Town & Country Planning (Control of Advertisement) (England) Regulations 2007 (as amended)

Application No: Y/32/21/A
Site Address: Land East of Drove Lane Yapton BN18 0EB
Description of works: Various non illuminated advertisements.

Barratt Static Banner
Barratt Logo
Flags - 600mm x 2200mm

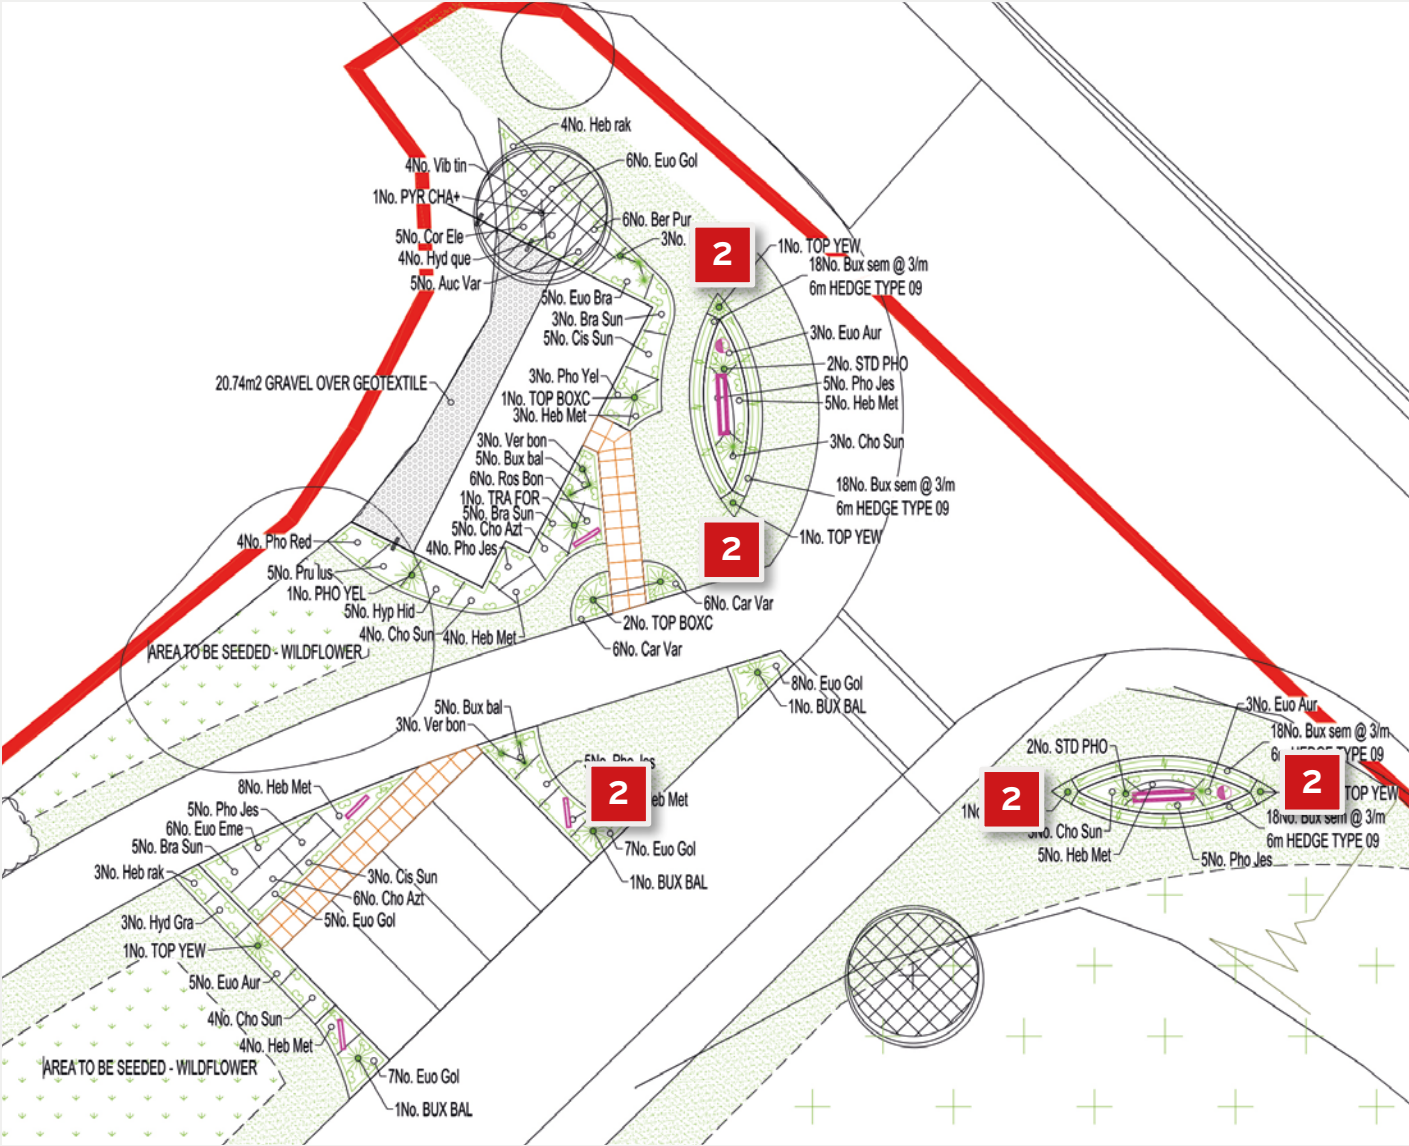
YPC seek a reduction in the number of fixed flags and signage within such a confined designated area of 'marketing area'. YPC is concerned that the size and quantity of signage items generates a cluttered and visually distracting aesthetic along this stretch of Main Road.
